Application No: EP/16/21/PL
Site Address: Land East of 1 The Way East Preston BN16 1QJ
Description of works: Replacement garage. This site is in CIL Zone 4 (Zero Rated) as other development.

Thank you for your internet representation made on 5th March 2021 which has been recorded as an objection with the comments as follows:

Client: Mr D Lynch		
Project Address: The Garage The Way East Preston		
Drawing Title: Existing and Proposed Plans and Elevations		
Drawing Number: 1241.01.g		
Scale:	As stated printed @ A1	
Date:	06/01/2020

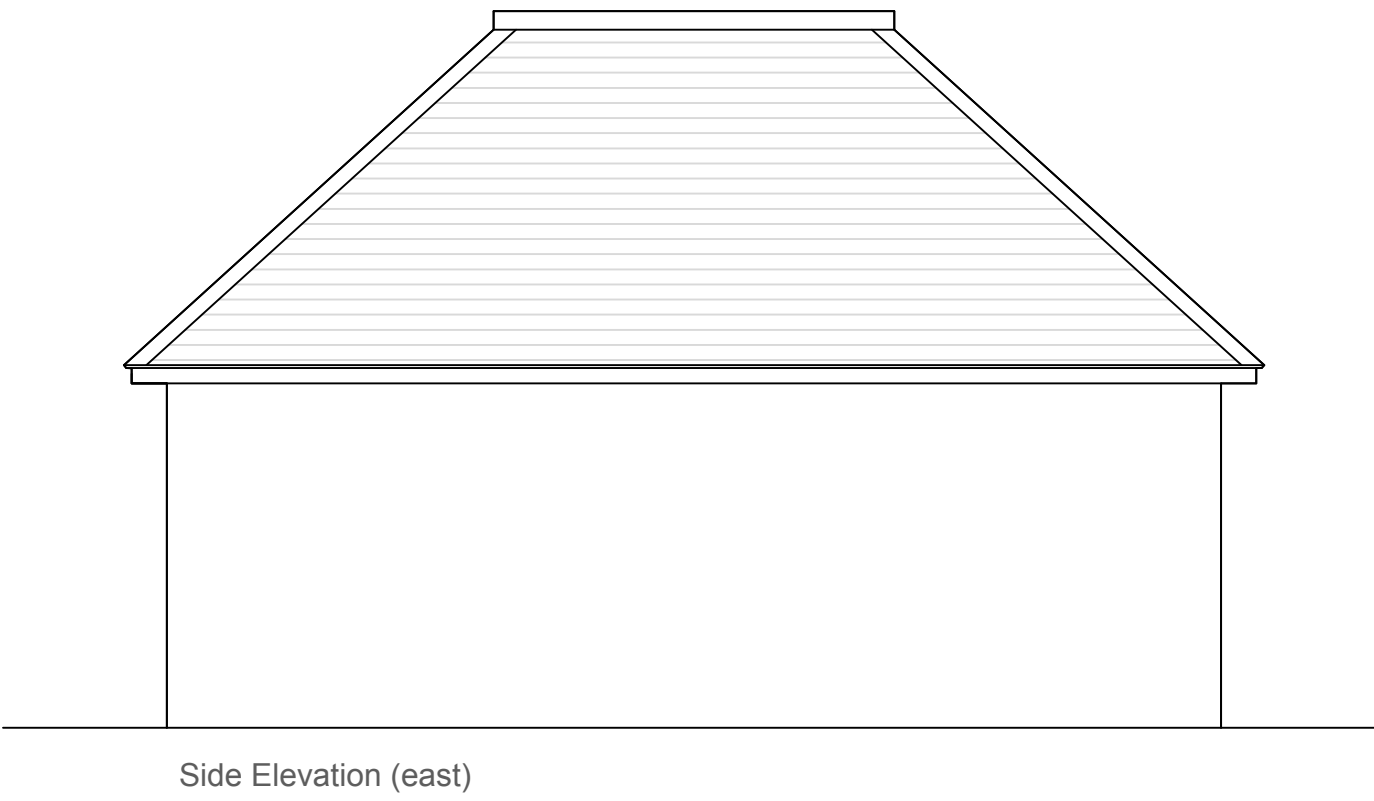
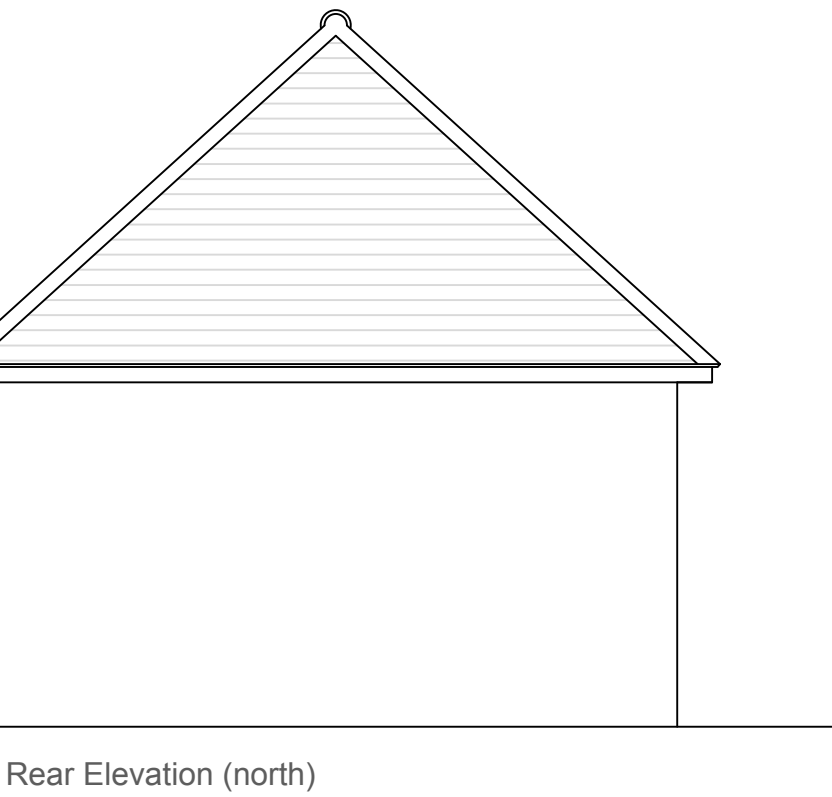
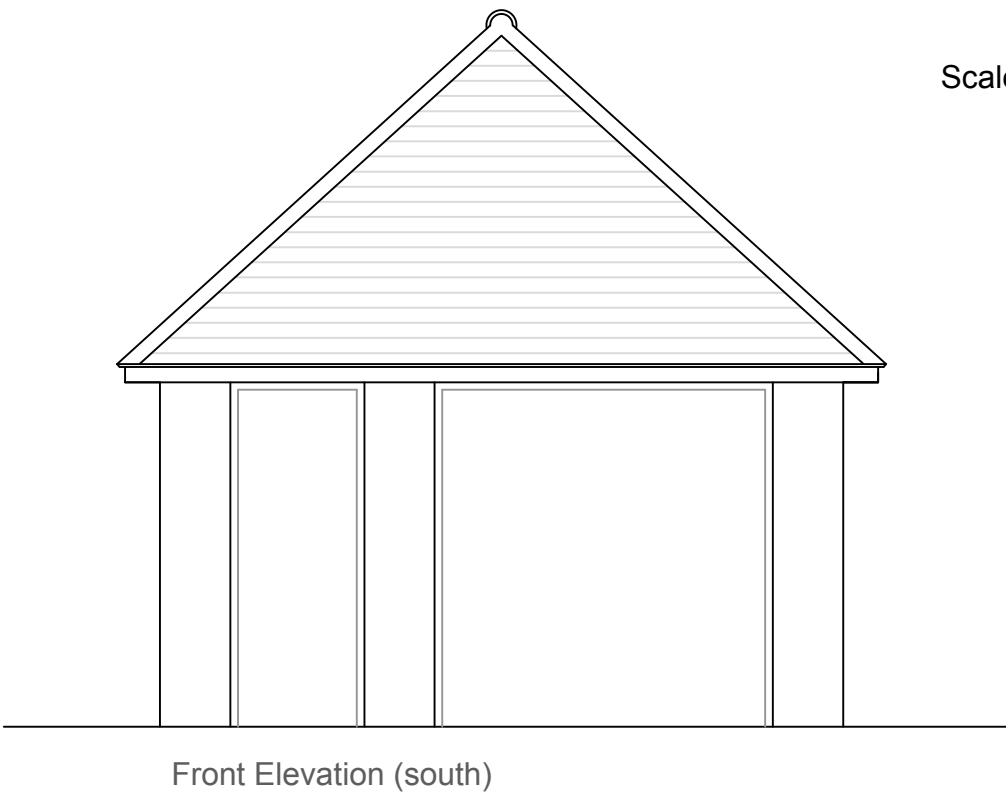
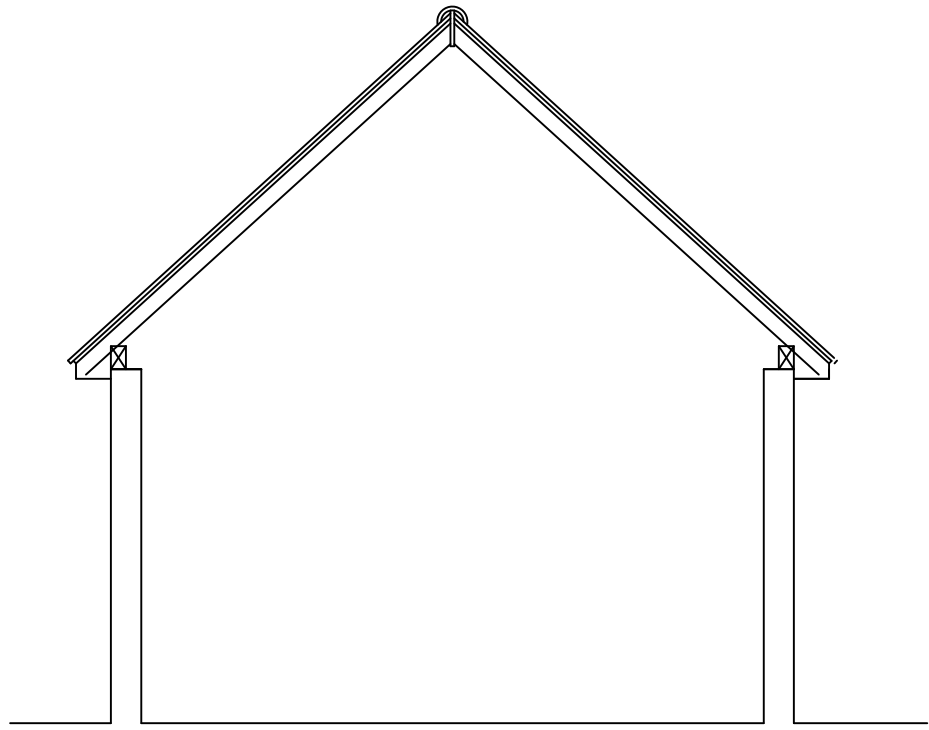
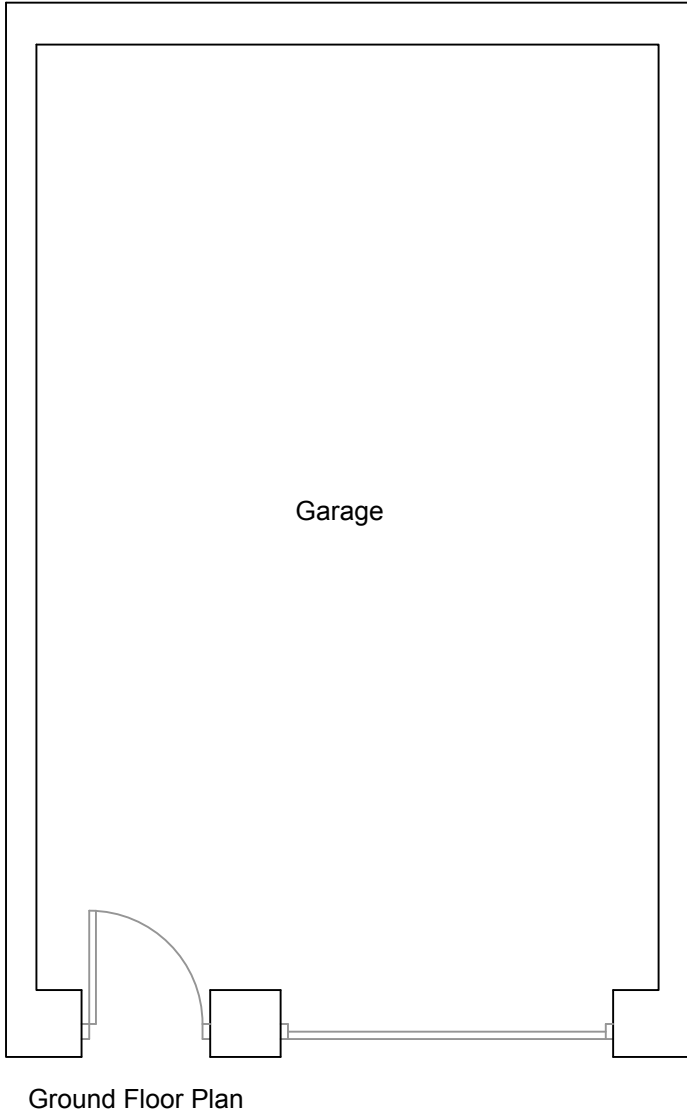
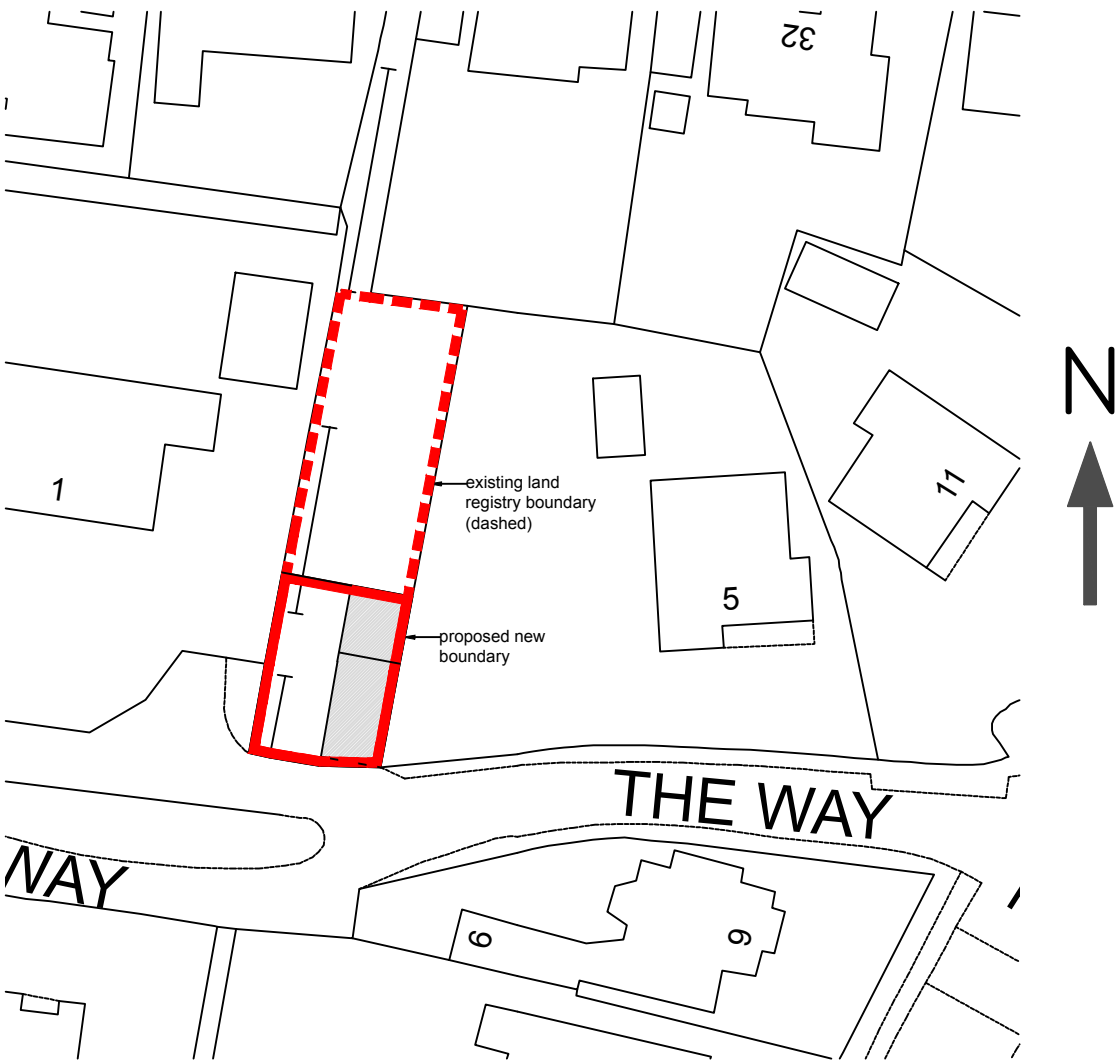
- the proposed gable frontage is over twice as high as the prior frontage and higher than the width of the road. It is also proposed to be within one metre of the road - altering the street scene considerably and out of step with the East Preston neighbourhood plan which recommends respecting the street scene

- the proposed door on the west wall of the lower storey would require access from the road, necessitating some form of hard stand right up against the drainage ditch. The Arun drainage checklist speaks of a three metre easement between such ditches and any build

- the proposal suggests that the building will be 'a replacement garage', when in fact the application is for a two storey building with a garage on its lower storey. Roof space would be very acceptable but the current plans suggest significantly more than storage space
